I would like to raise concerns regarding the following planning application for two single storey extensions to Sunny Bank, Whalley Road, Simonstone:-

PLANNING APPLICATION NUMBER - 3/2023/0560

Sunnybank, BB12 7HT

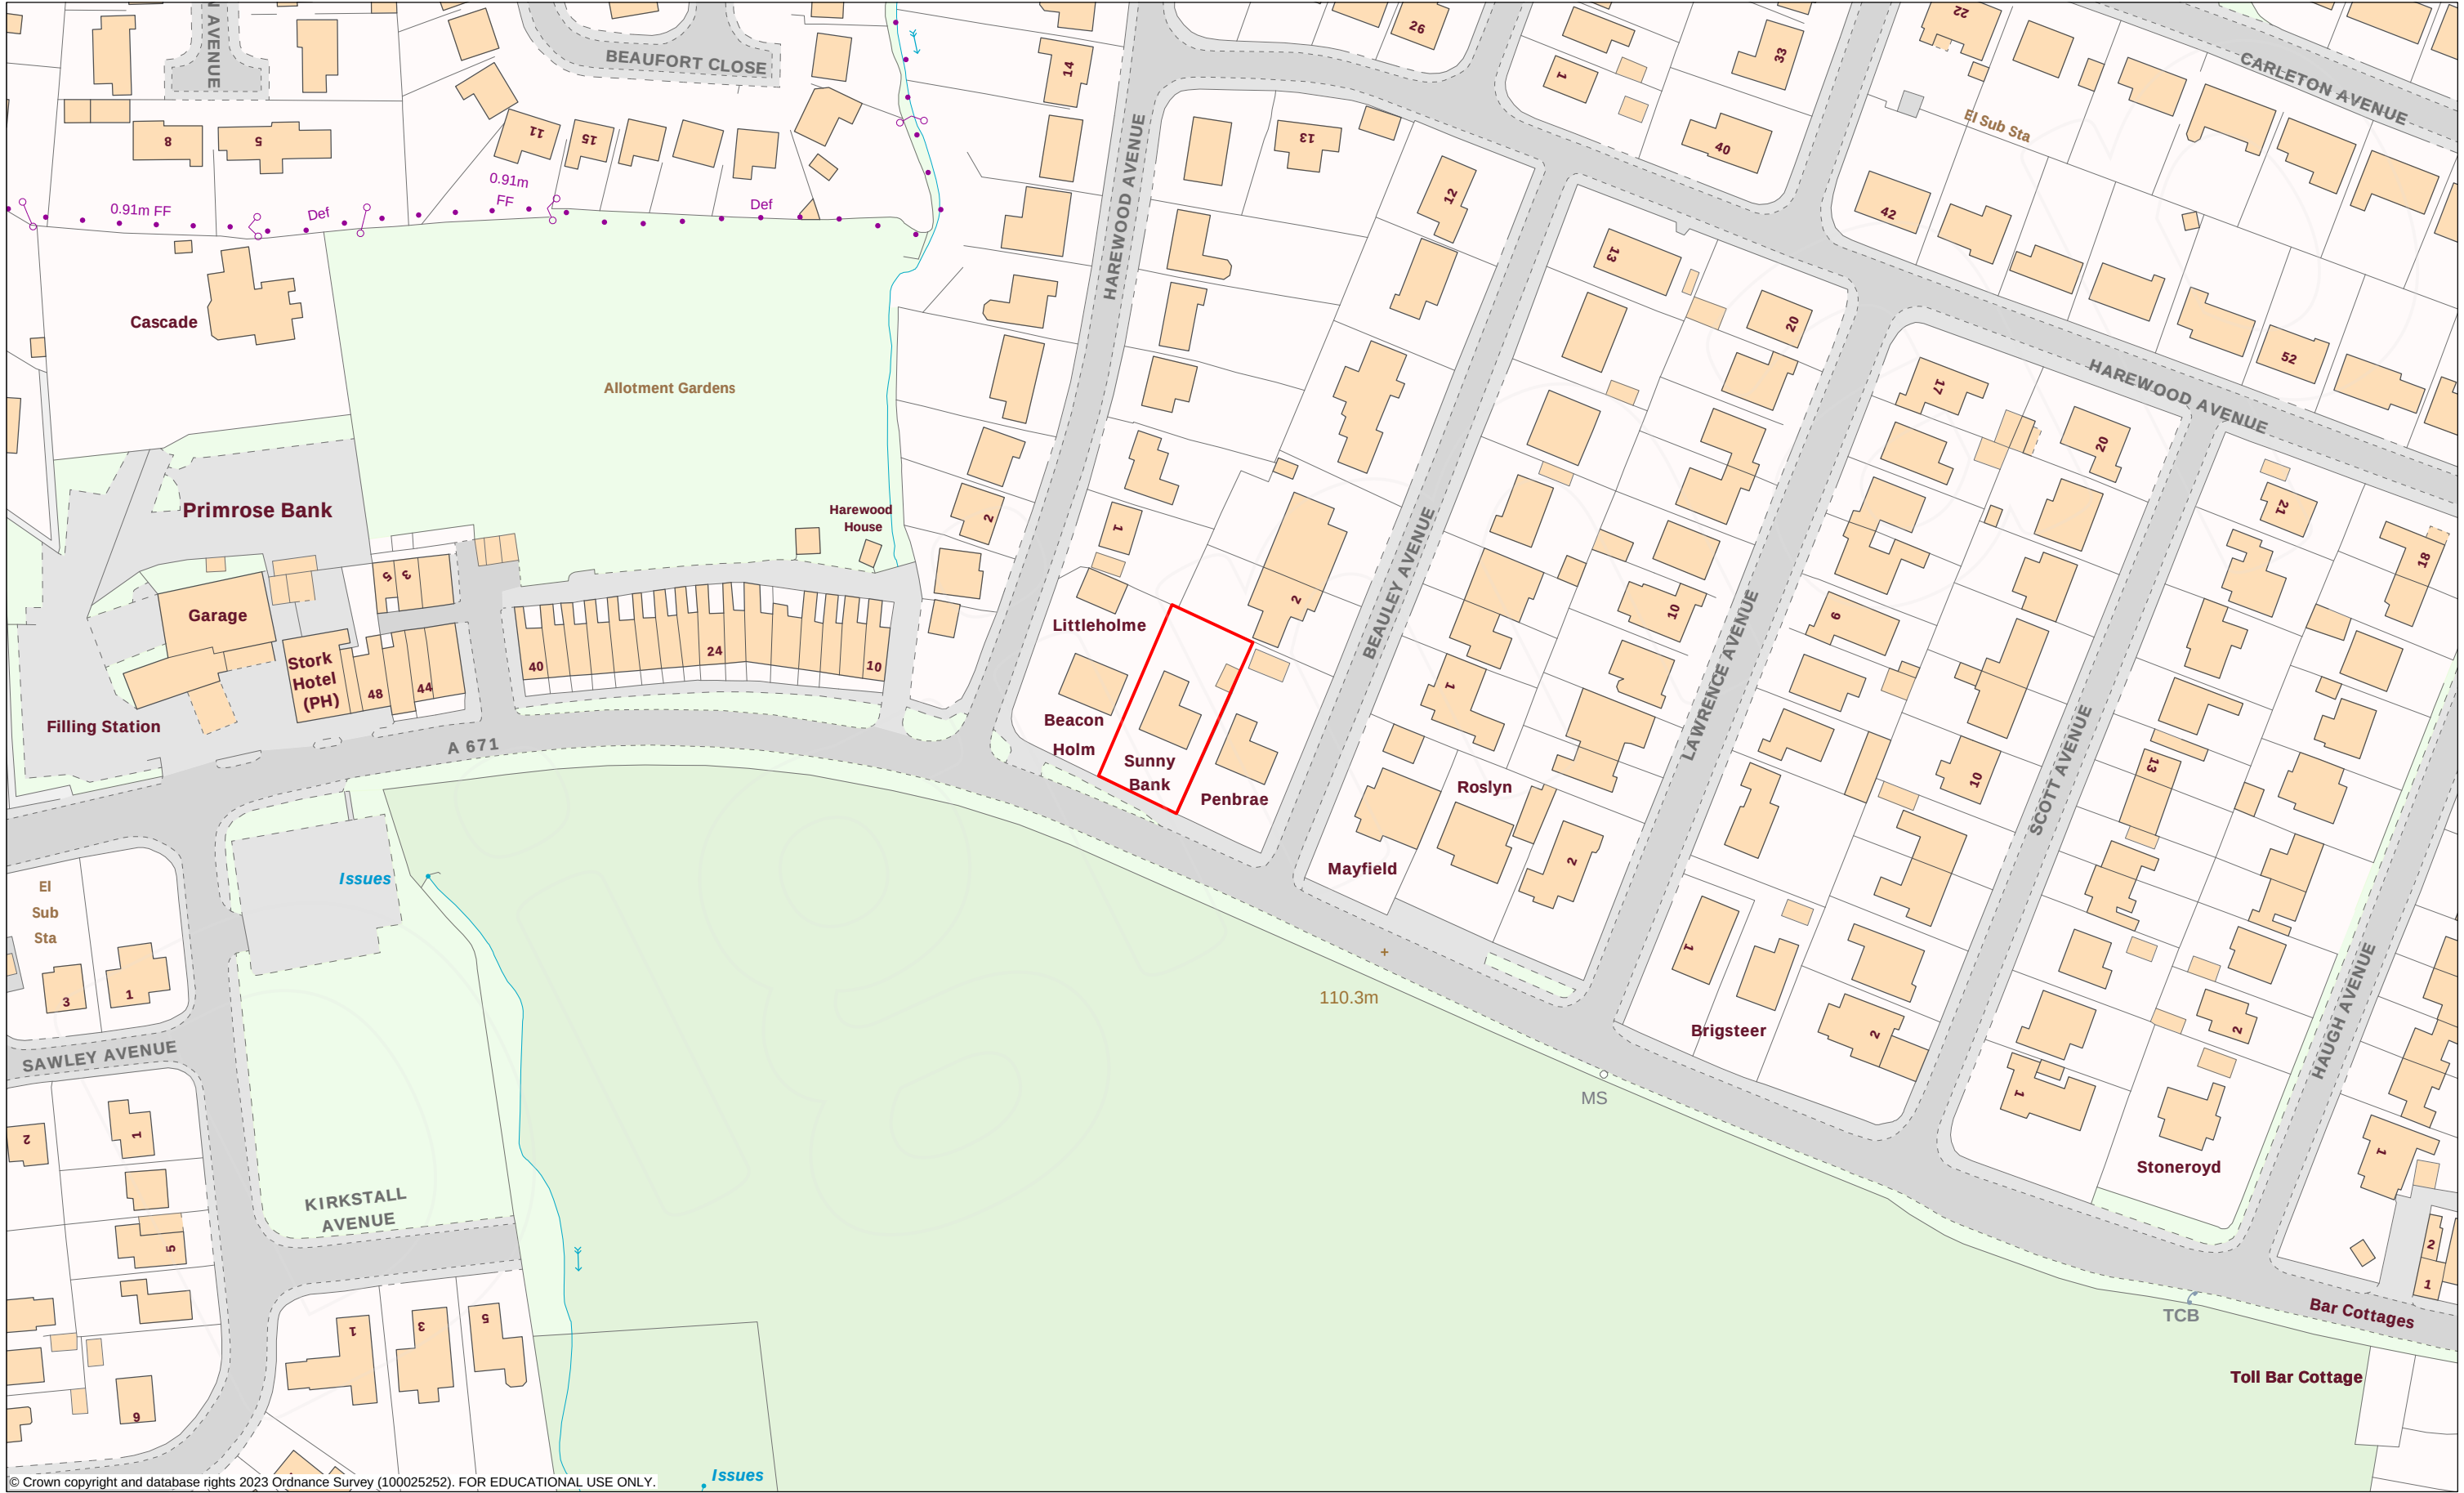
On the plans submitted by the architect for the above application, the boundary of the property does not run in a straight line

Proposed Site Plan
1 : 250

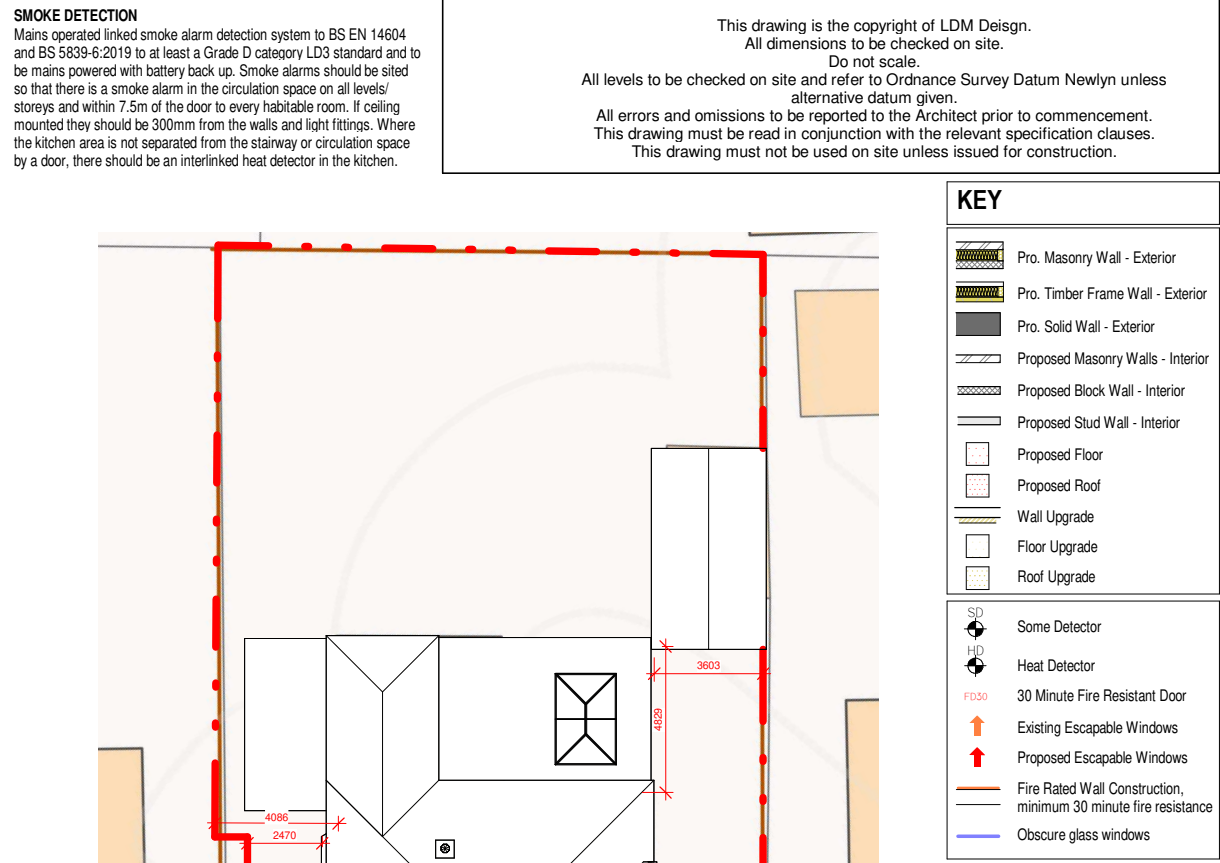
Taking this into account, the 3000mm wide extension to Sunny Bank comes approximately 30mm. Whilst I am unsure of the exact proximity allowed when building up to this seems rather close.

The application also states that no pruning or removal of hedges will be carried out, which would appear to be difficult to avoid if

building the proposed size of the extension.
